Tweed Valley Hospital Development

Addendum 1 to Design Report

Issued for: State Significant Development Application – Response to Submissions

130559-BON-CIV-RPT-006

Drawing Title
SOIL AND WATER MANAGEMENT
CALCULATIONS
- SHEET 2 OF 2

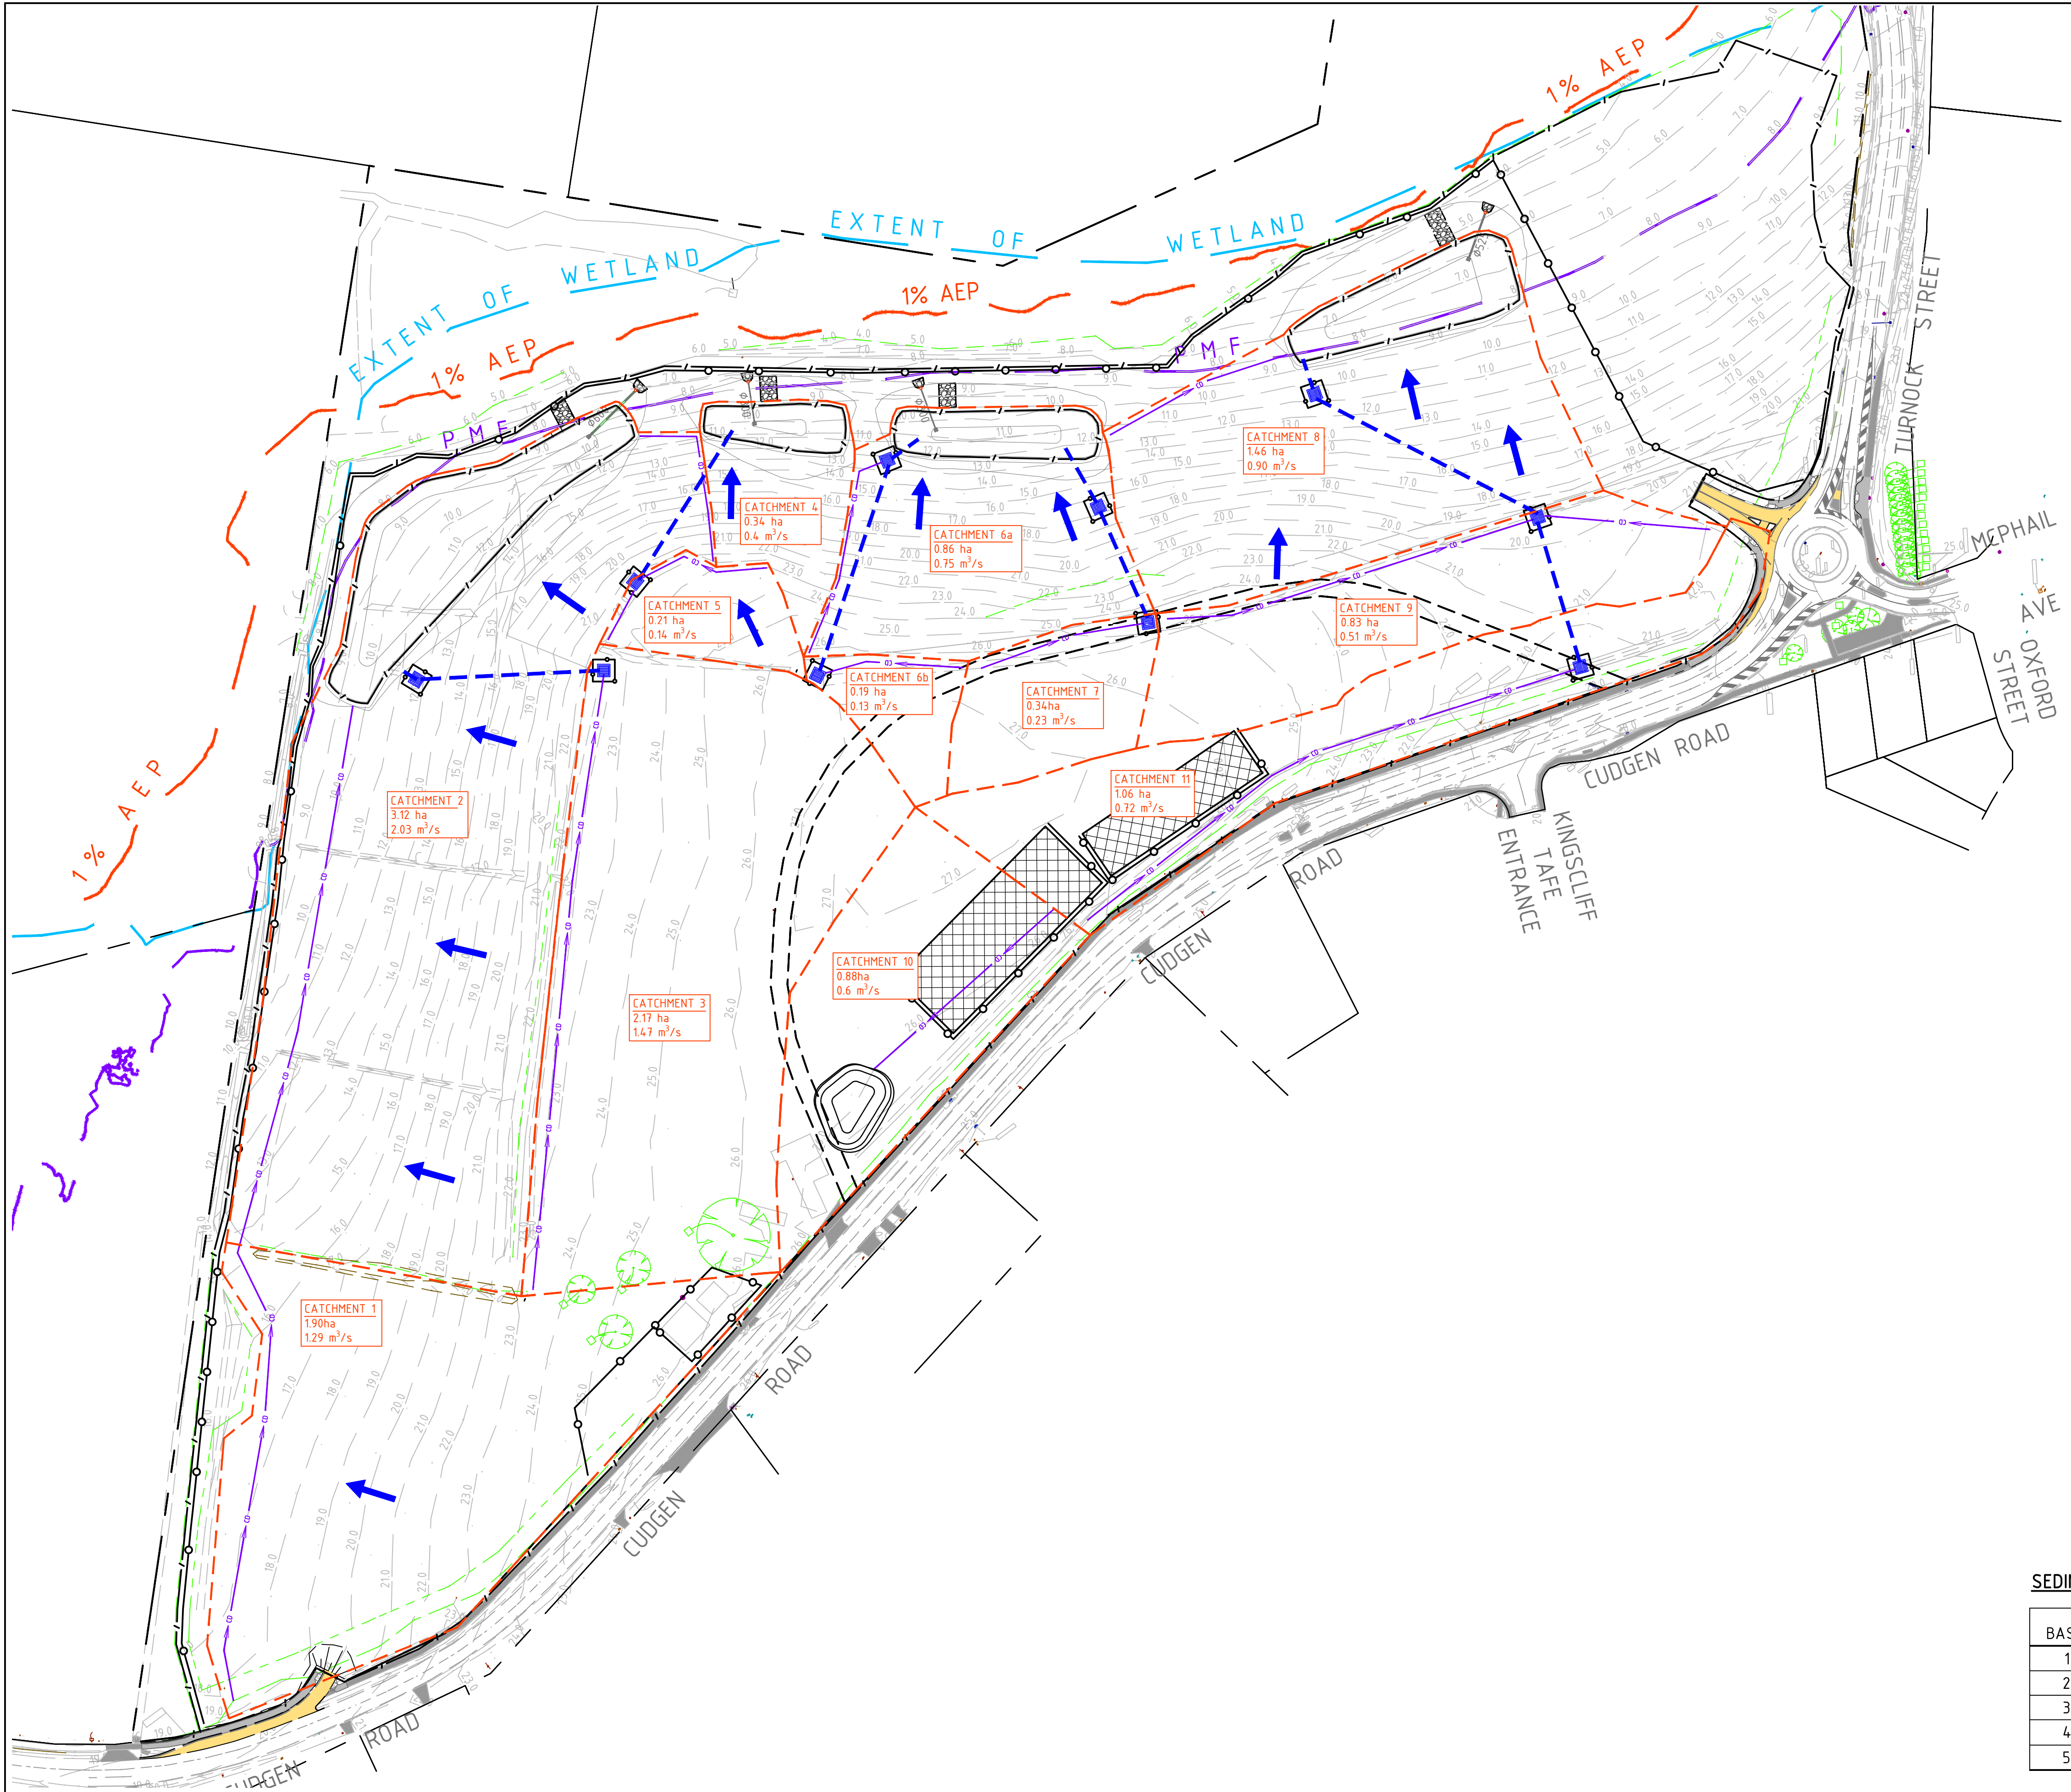
- *more detail is needed on the sedimentation pond design and the lawful point of discharge for the development.*
- *(Item tt) Details of the sediment basins and sizing calculations (drawings C0006 and C0007) are missing from the Civil and Structural Design Report (Appendix X) and should be provided.*

Drawings C005 to C009 have been updated and are provided at Appendix A of the Submissions Report.

Designed PA
Drawn PA
Scale -
Date 03.09.18
Sheet A1
Project Director Approved Date
Project Ref 20 10748 01
Drawing No C055
Rev P2

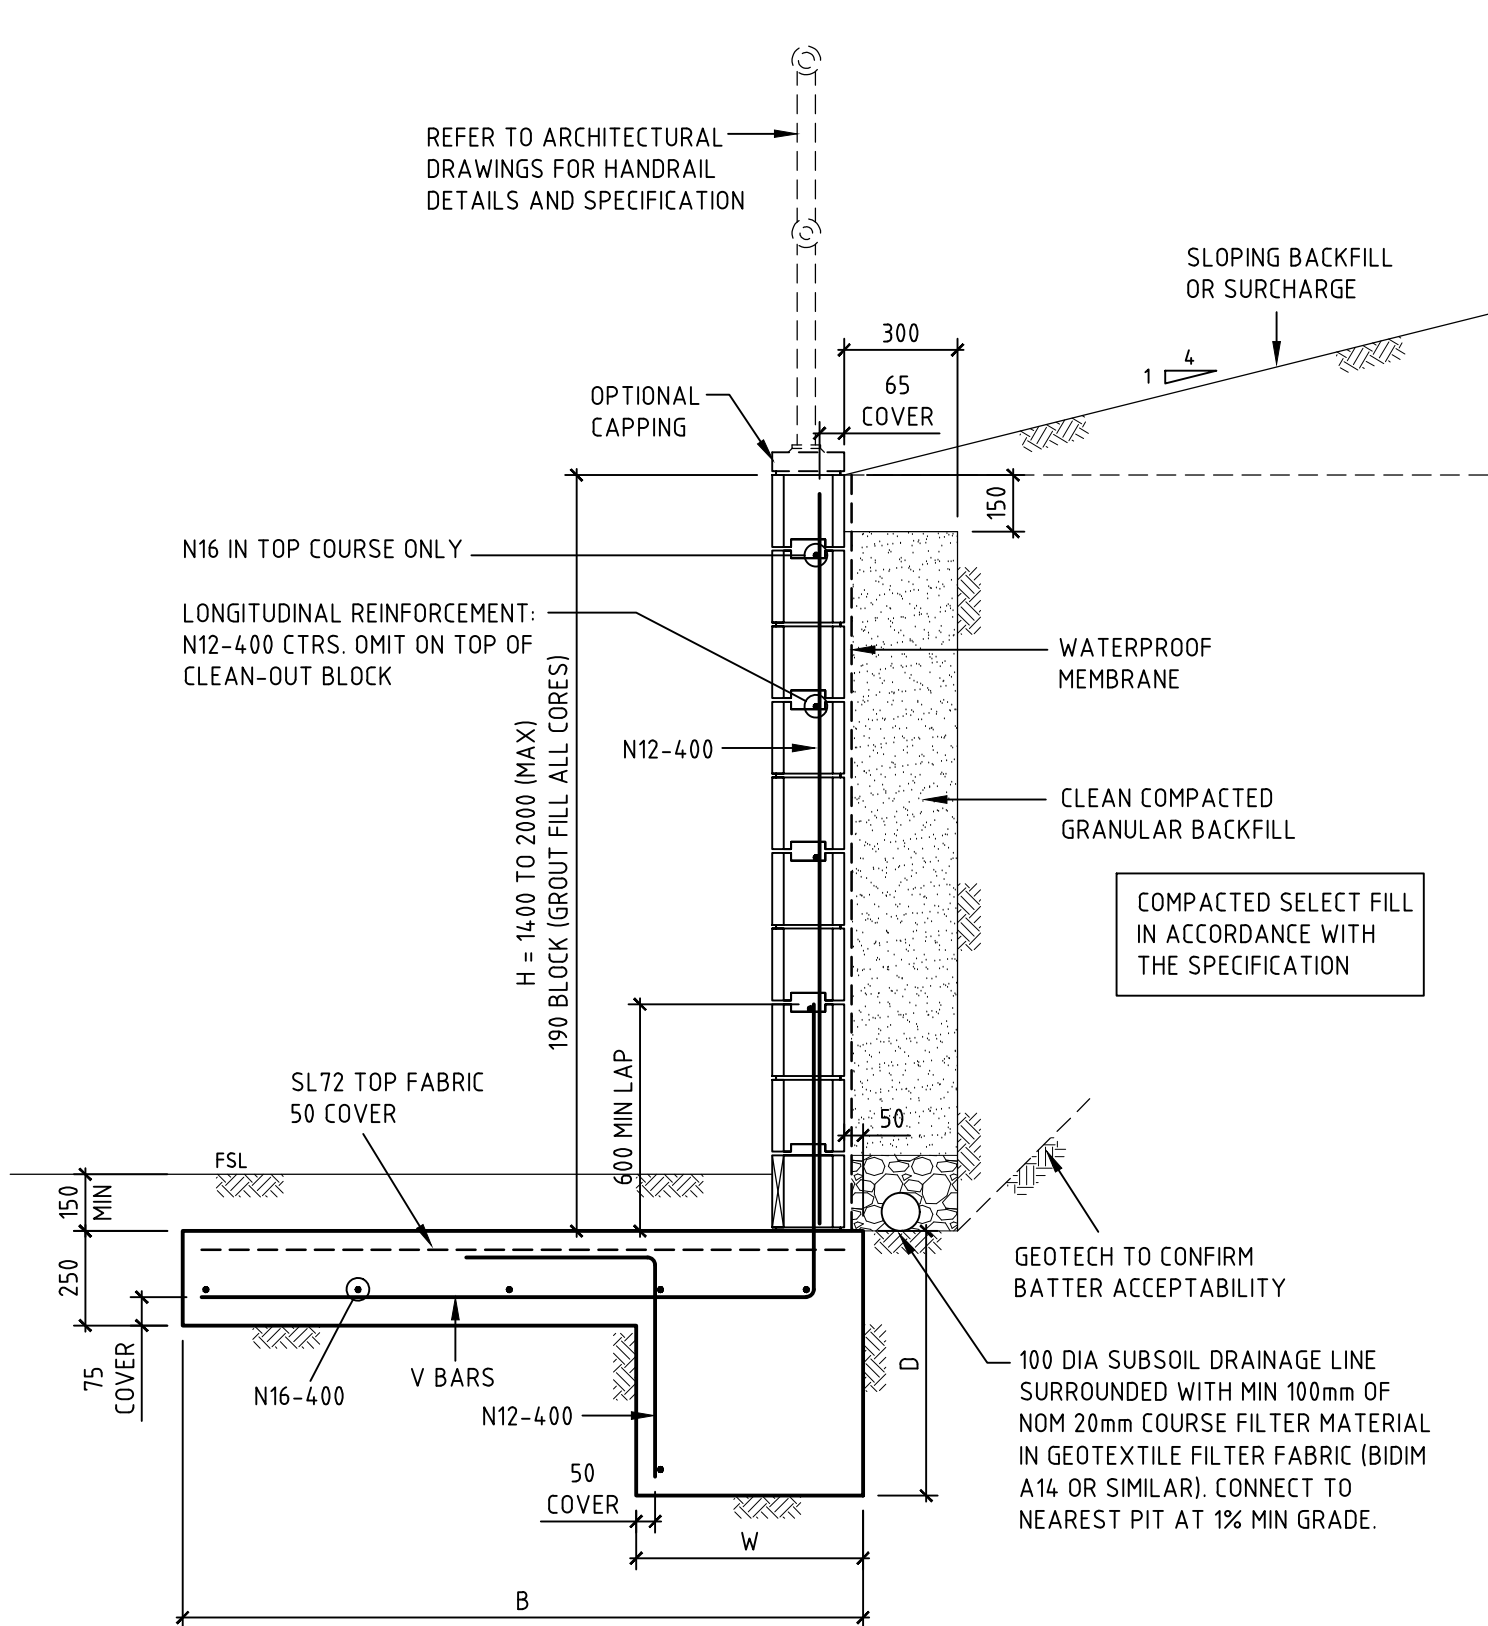
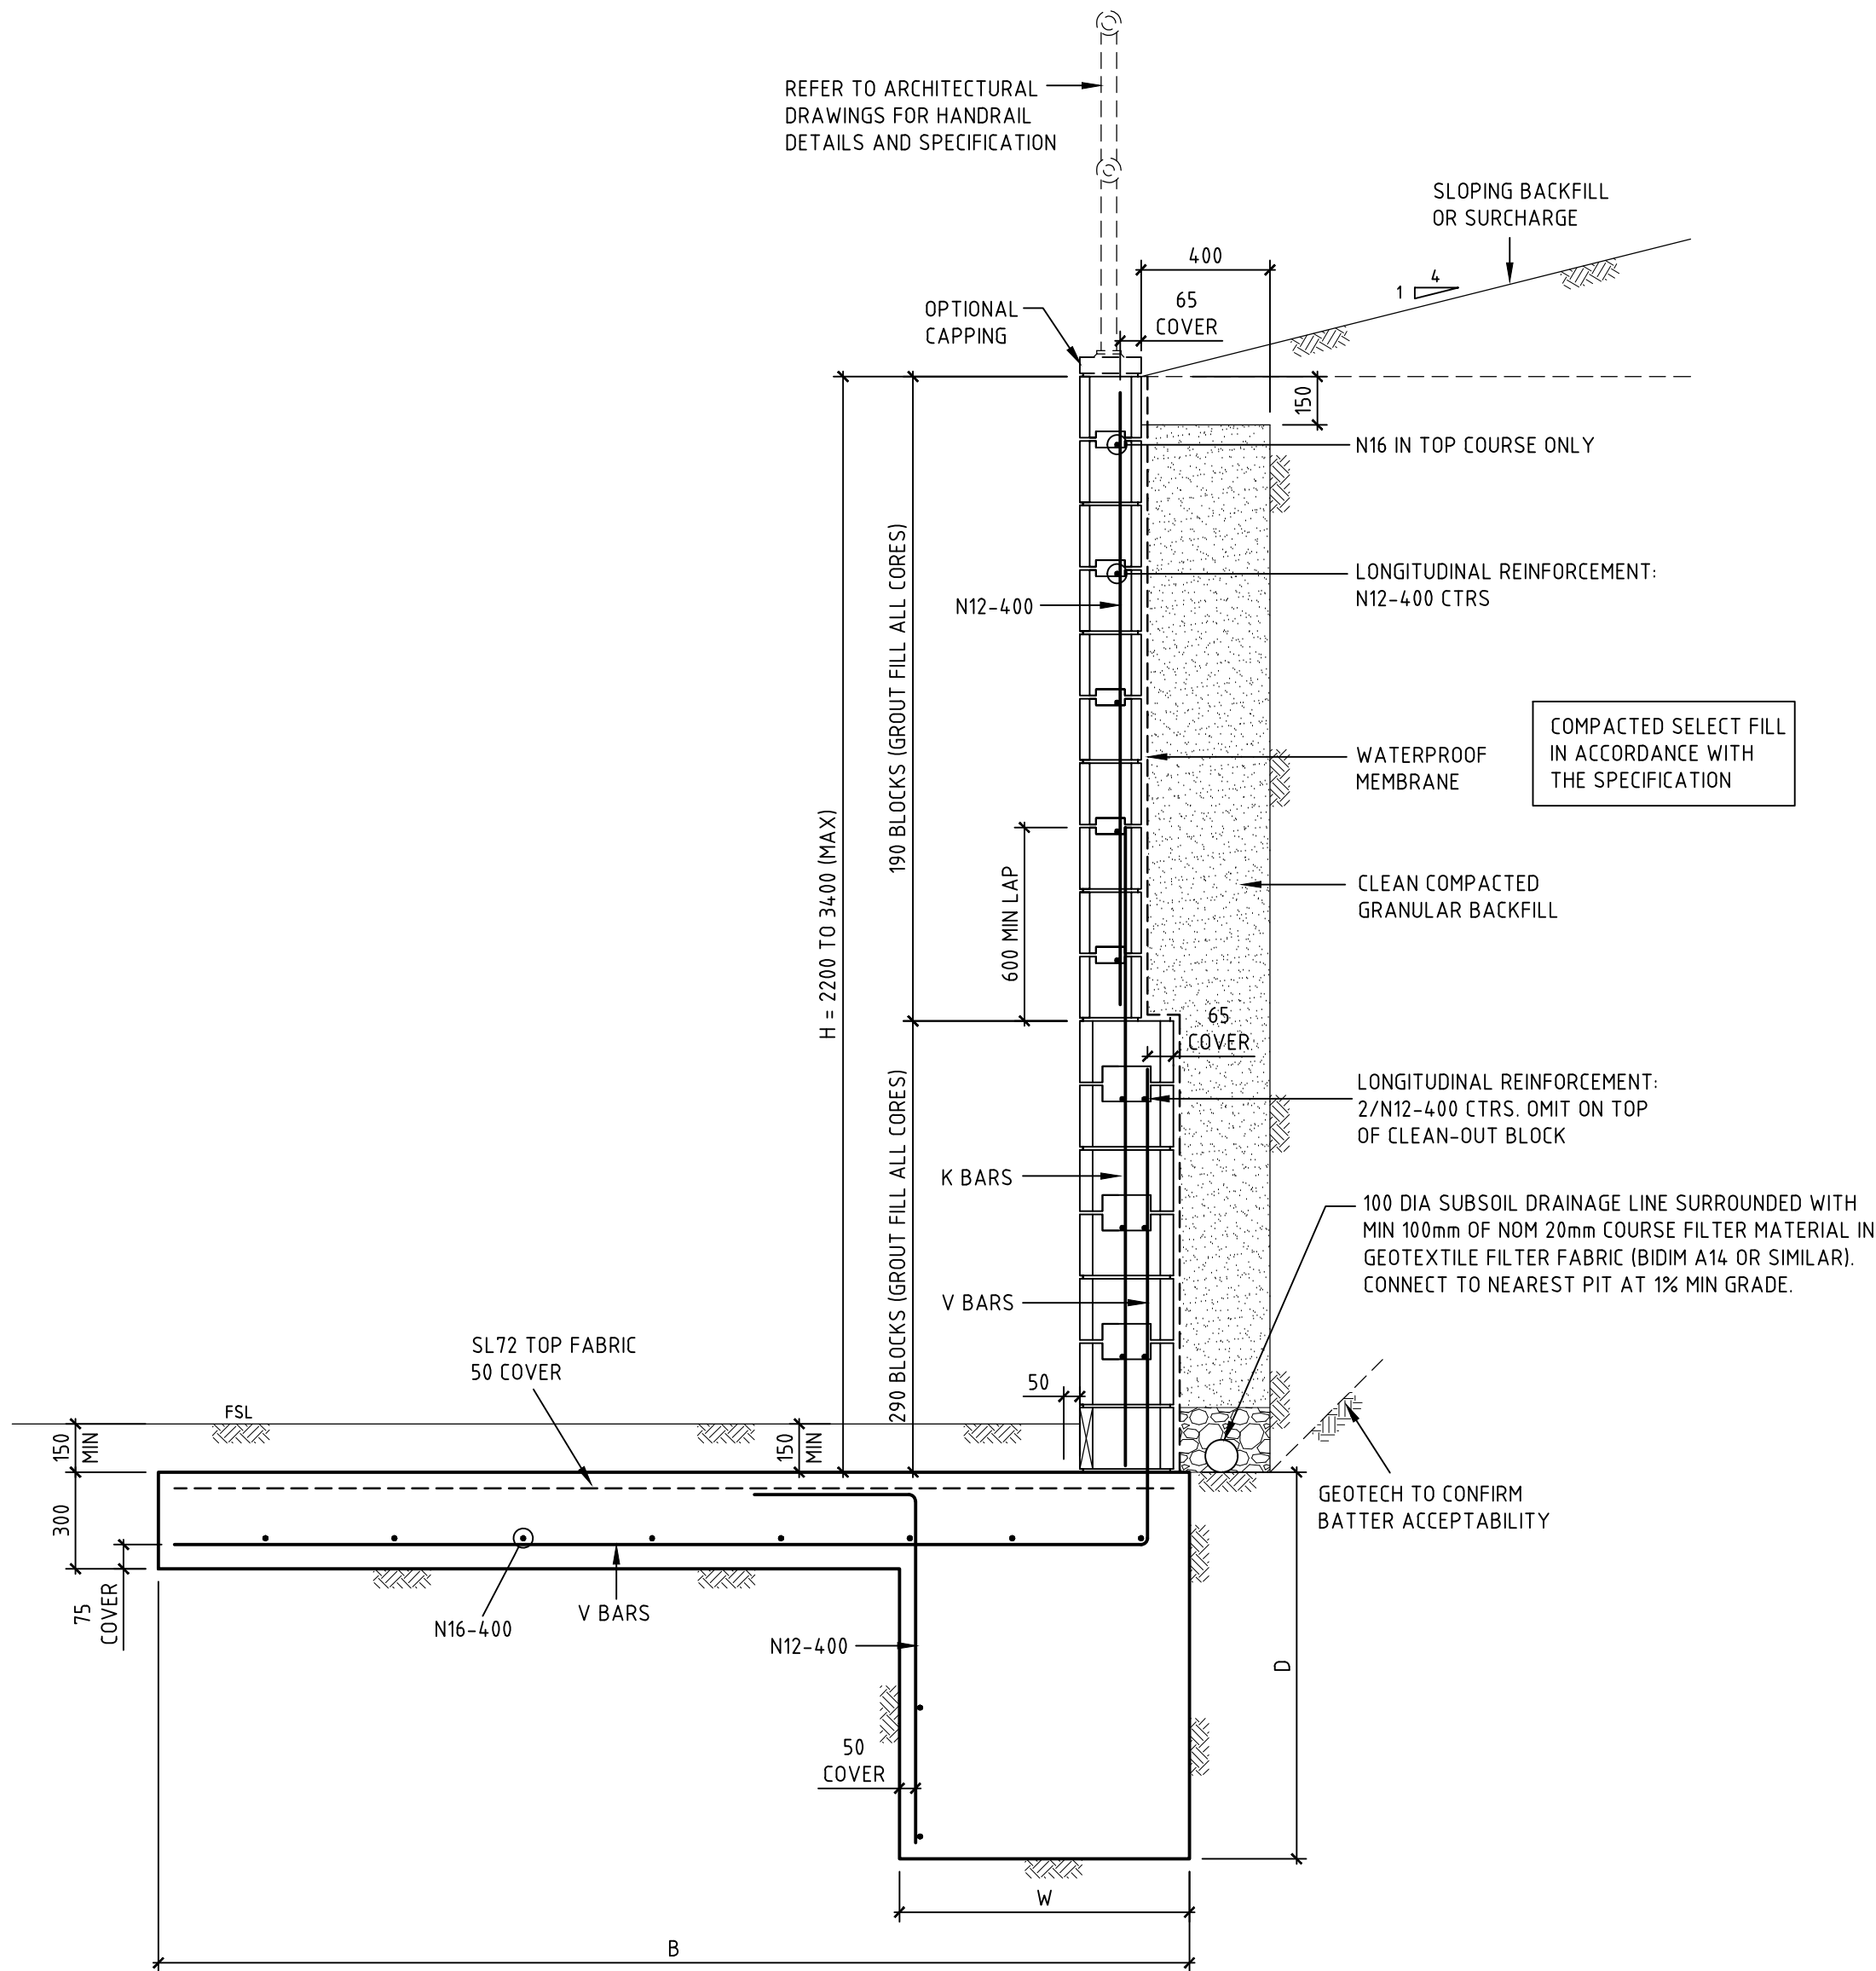
*The extent of cut and fill should be over laid on the survey plan and the areas of cut / fill should be hatched identifying the resultant levels after the landform modification.
The Response to submissions should also identify whether retaining walls or any form of batters are anticipated to be built in the future (or part of the Stage 1 works) to support the filled areas, especially on the western section, so that the extent of the proposed works (both for Stage and Concept Proposal) are clear. Should retaining walls be proposed as part of the Stage 1 works to support the filled areas in the western section of the site, then the details of the visual impacts of the retaining walls on the surrounding properties should be provided.
The Stage 1 works include benching of the site with a number of retaining walls. RLs of the top of the walls and sections through the site identifying the height of each of these retaining walls should be provided. Please clarify whether these retaining walls are required to accommodate the car parking areas in the future.*

- Sections of the site are provided on drawings C020, 021, 022 and 023. The sections show the general site grading to better visualise the proposed site levels.
- Typical retaining wall sections and details are shown on drawings C055 and 056. The sections are for retaining structures up to 3.40metres in height. The progression of the design aims to minimise the use of retaining structures and it is not proposed to have any retaining walls over 3.40metres in height.
